**Application Reference: 2025/1072****Site Address:** Hudroyd House, Genn Lane, Ward Green, Barnsley, S70 6NW**Introduction:**

This application seeks full planning permission for the erection of extension to existing detached garage and replacement of flat roof with pitched roof.

Block Plan  
Scale 1:500

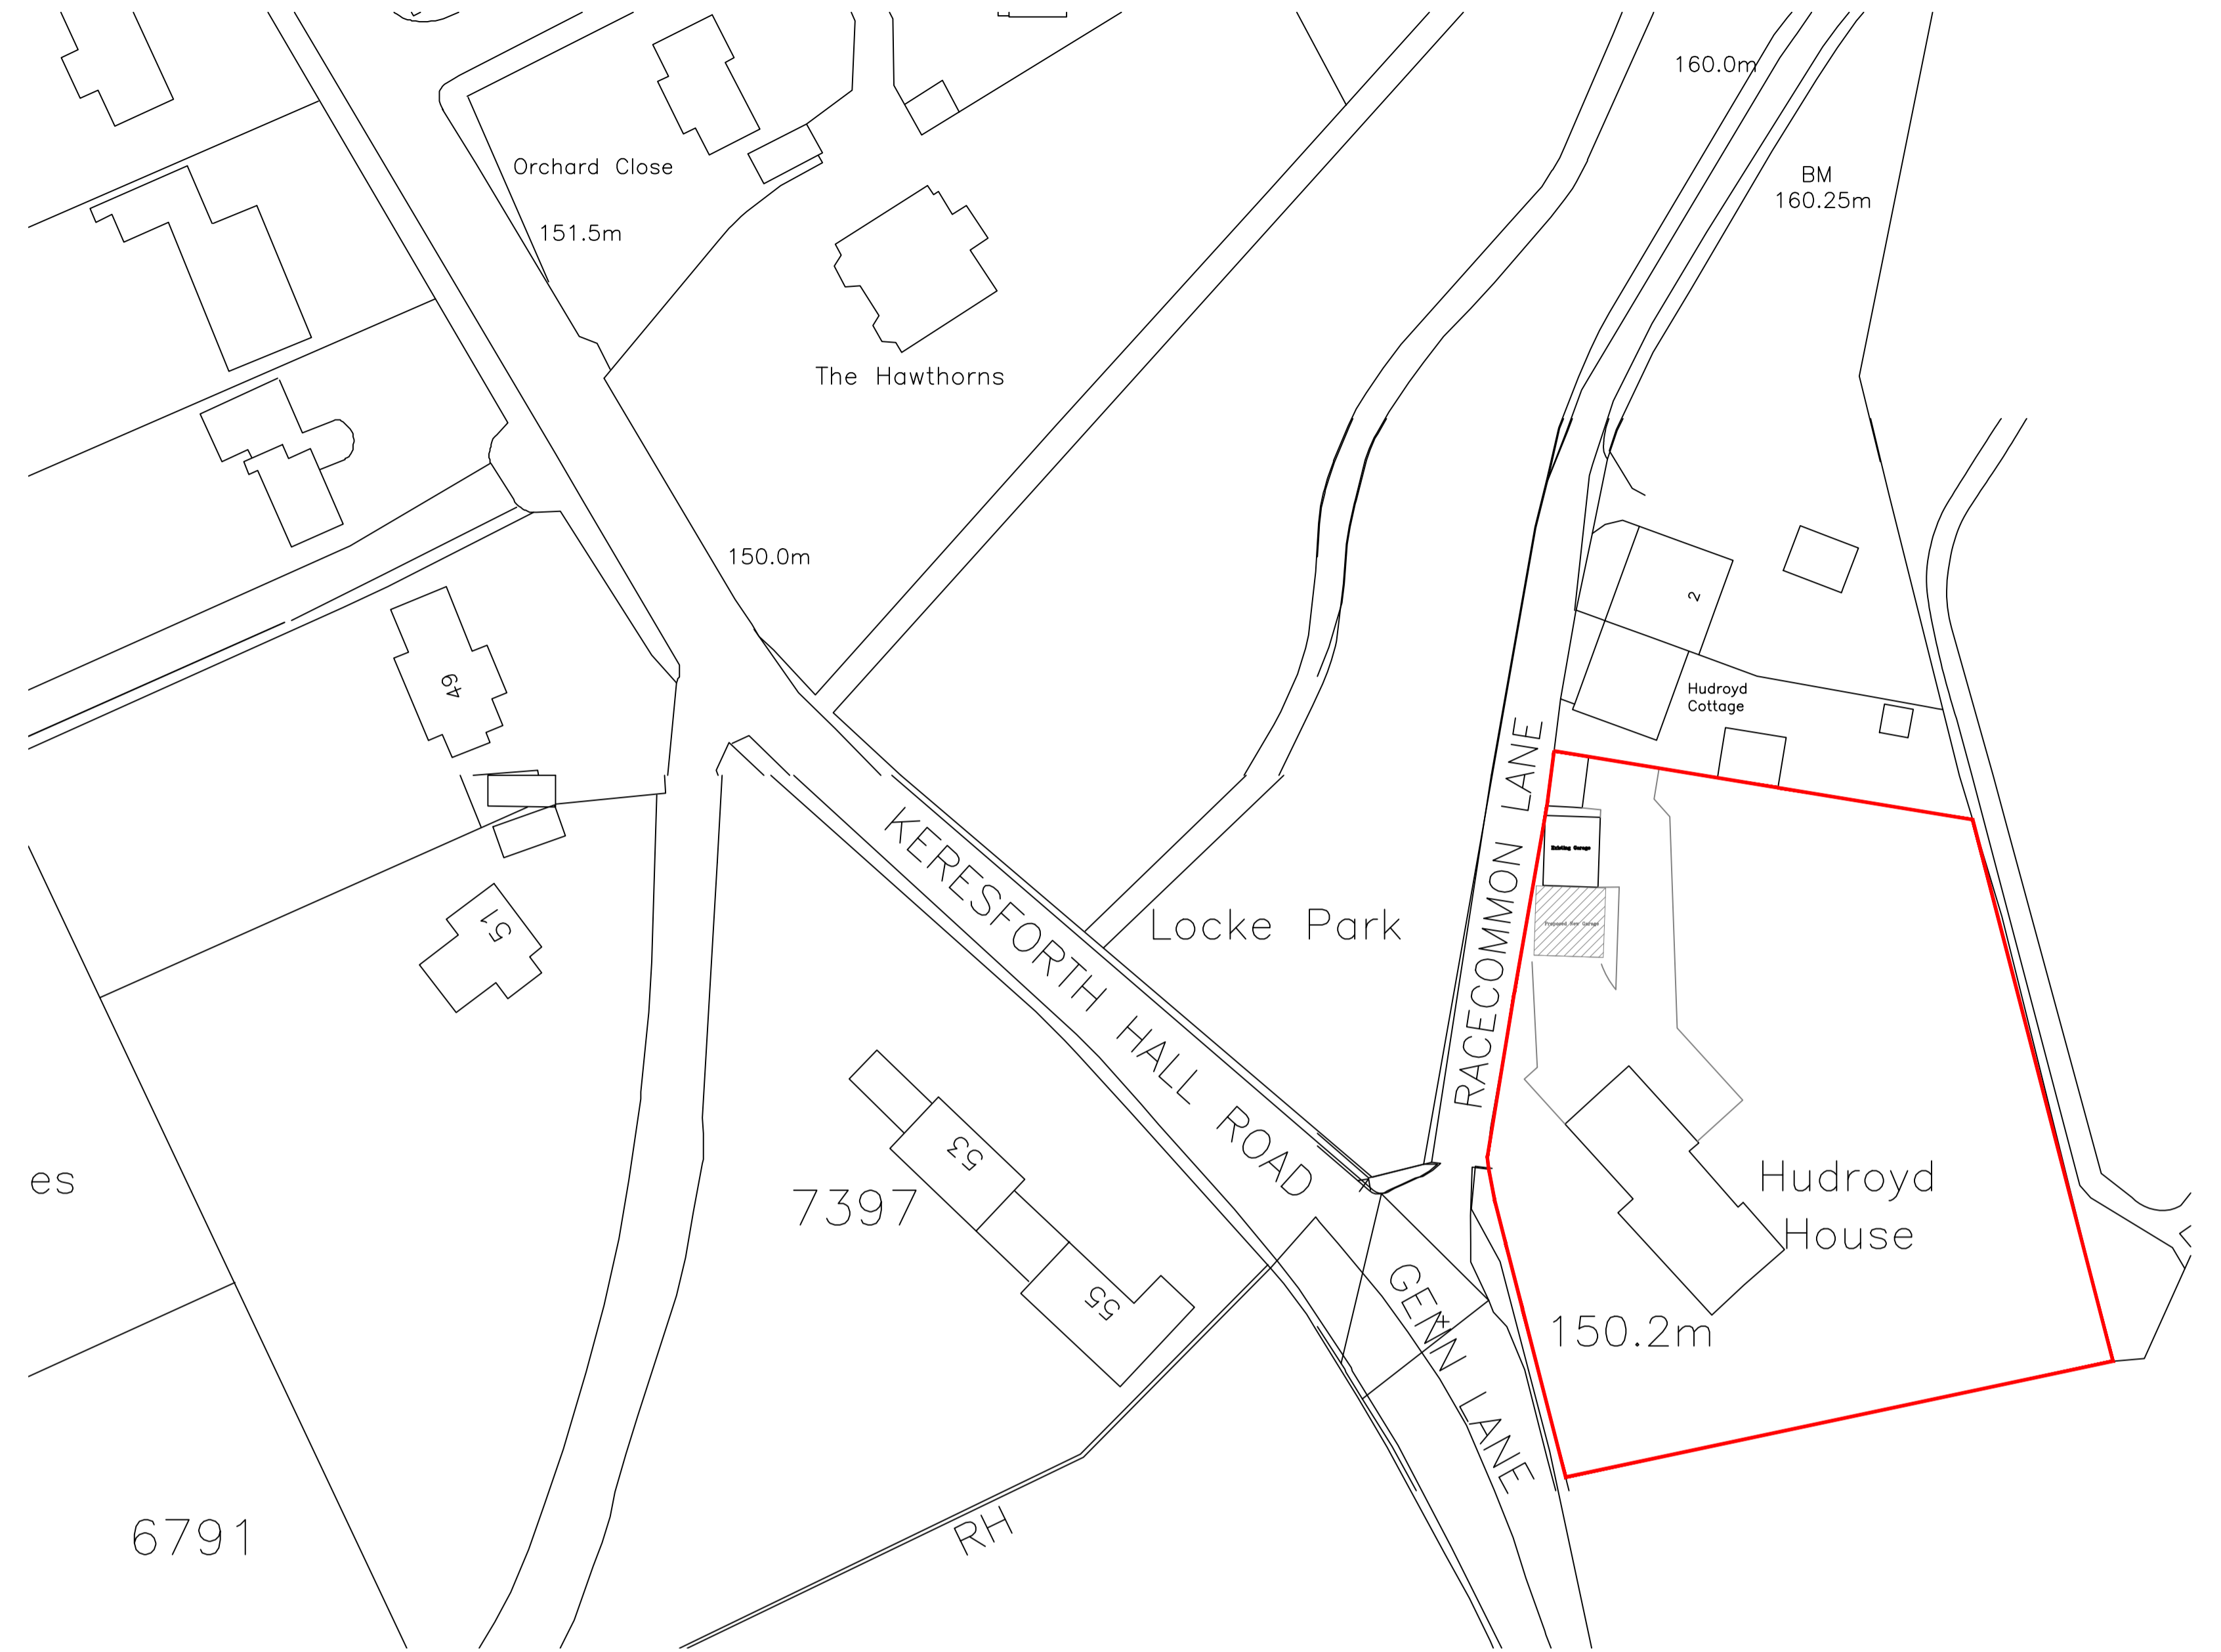
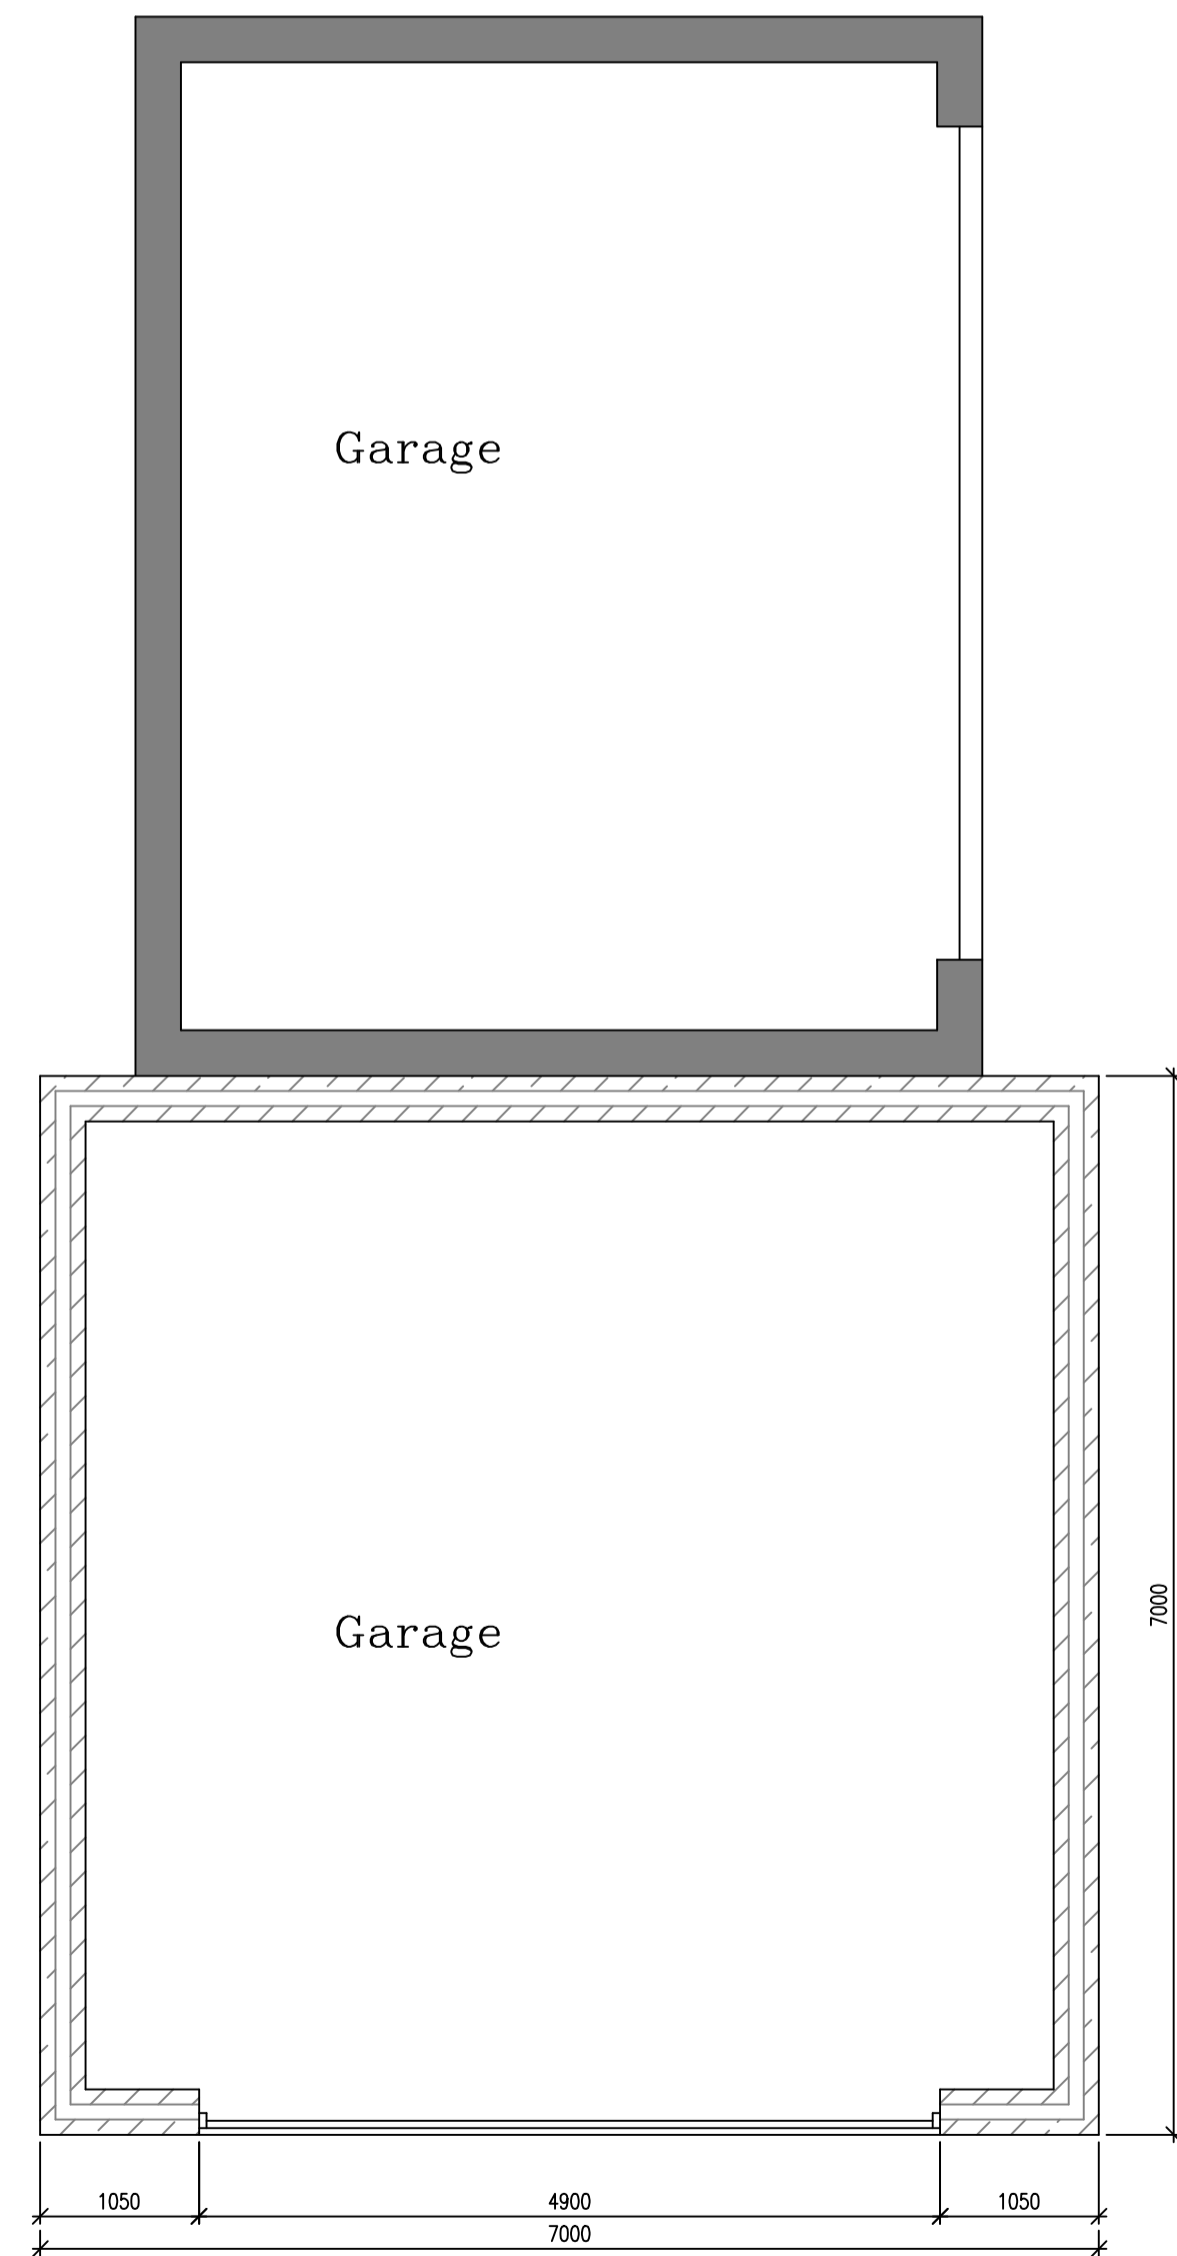
As mentioned previously the existing garage is located adjacent to the Racecommon Lane boundary, with the proposed garage to be attached to the southern side elevation of the existing garage. Whilst the proposed garage would be located in a roadside setting, adjacent to Racecommon Lane, the existing wall will shield much of the impact of the proposal. In addition, the proposed garage would be set back from the main highway, Genn Lane by approximately 30m, with the trees within Locke Park providing some screening of the development from the north, and the dwelling and the existing vegetation providing screening from the south; this carries significant weight in favour of the application.

The closest residential property is located to the north of the site; however, the proposed garage is separated by the existing garage and the driveways associated with the application site and the neighbouring property and any overshadowing would occur over this area rather than private amenity space.

Drawing  
Existing & Proposed Plans, Elevations & Block Plan

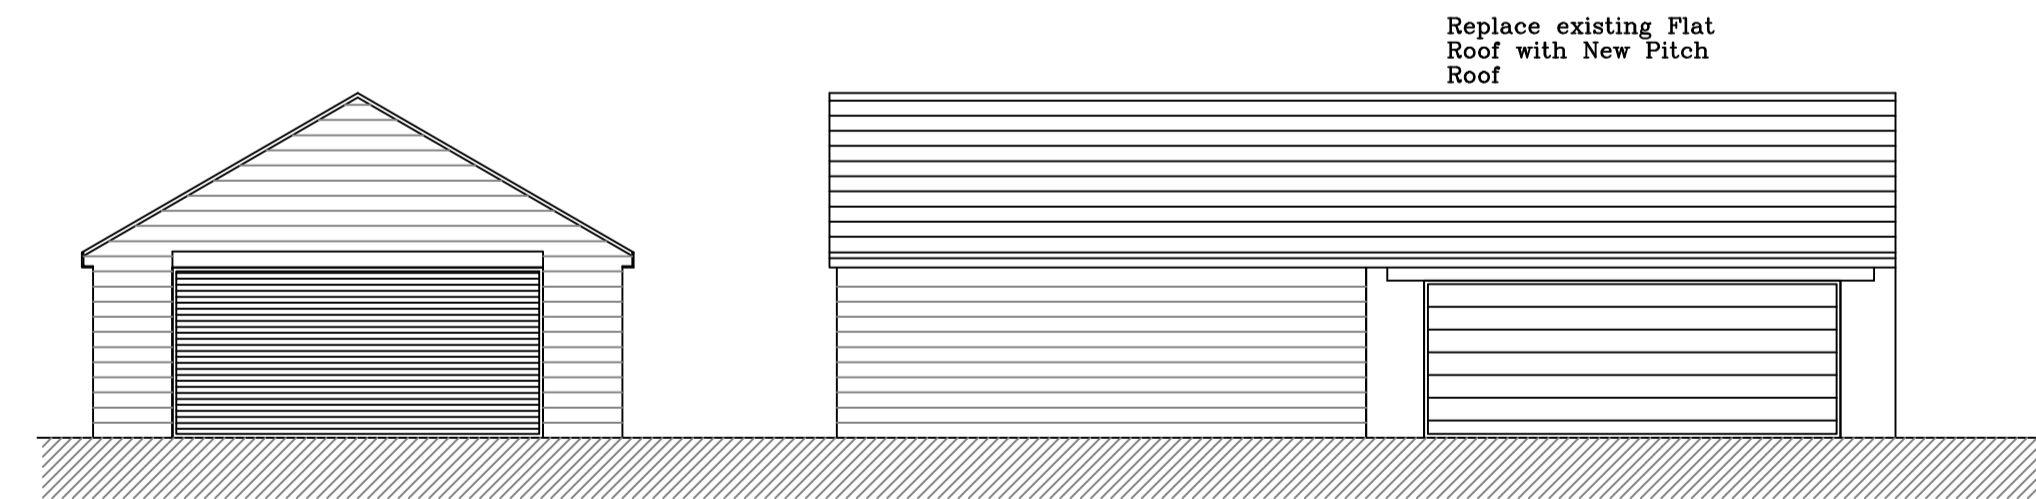
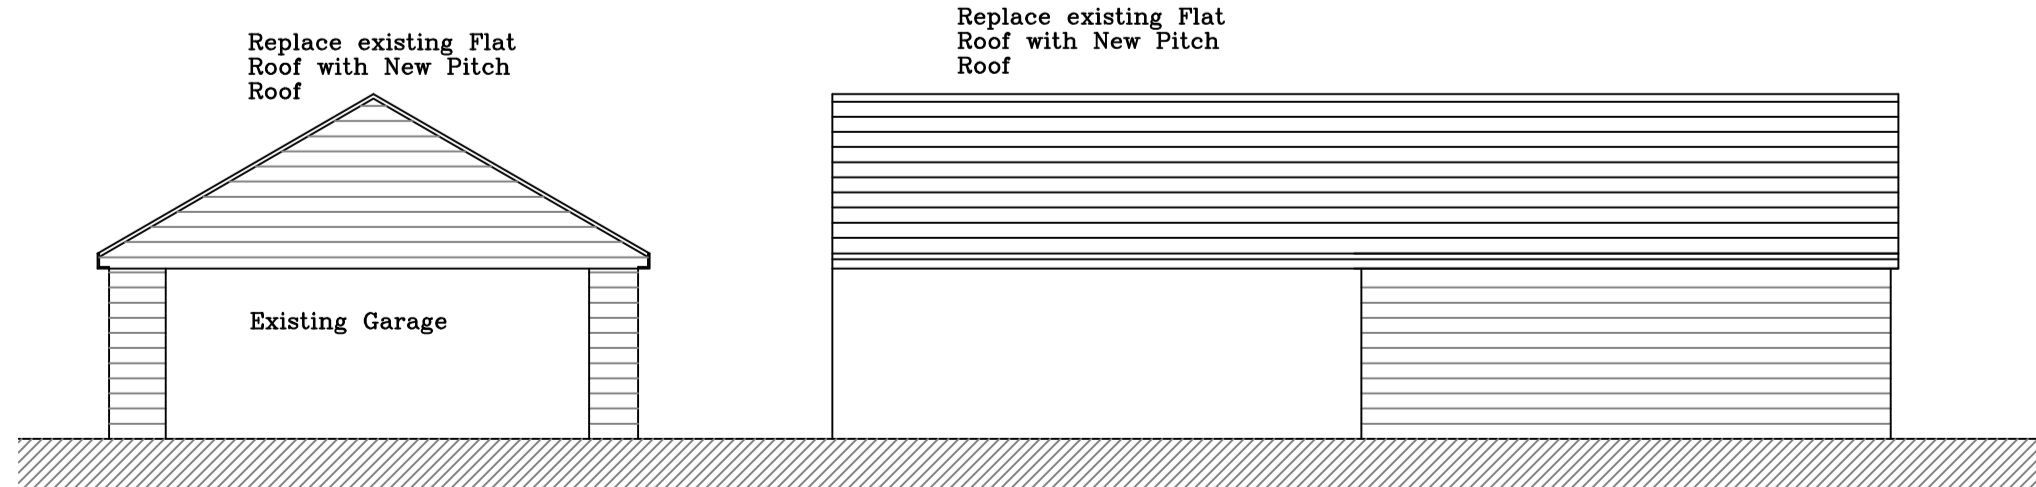
It is acknowledged the proposed garage is of a significant size, and that the ridge height and dimensions exceed the guidance by 500mm. The existing and proposed detached garages

The design of the proposed garage extension relates well to that of the original dwelling in terms of roof style, pitch and detailing and the materials proposed. This carries considerable weight in favour of the application, and it is therefore considered that the proposed extension is acceptable in terms of visual amenity and in compliance with Local Plan Policy D1, Policy HE3 and Policy GB2.

The materials used in the construction of the garage walls shall match those used in the construction of the existing garage including stone type, colour, face dressing and pointing detail

The roof shall be covered using either a natural stone roofing slate or blue/grey slates or good quality riven artificial alternative that emulates this closely and shall be laid in diminishing courses with matching ridge tiles
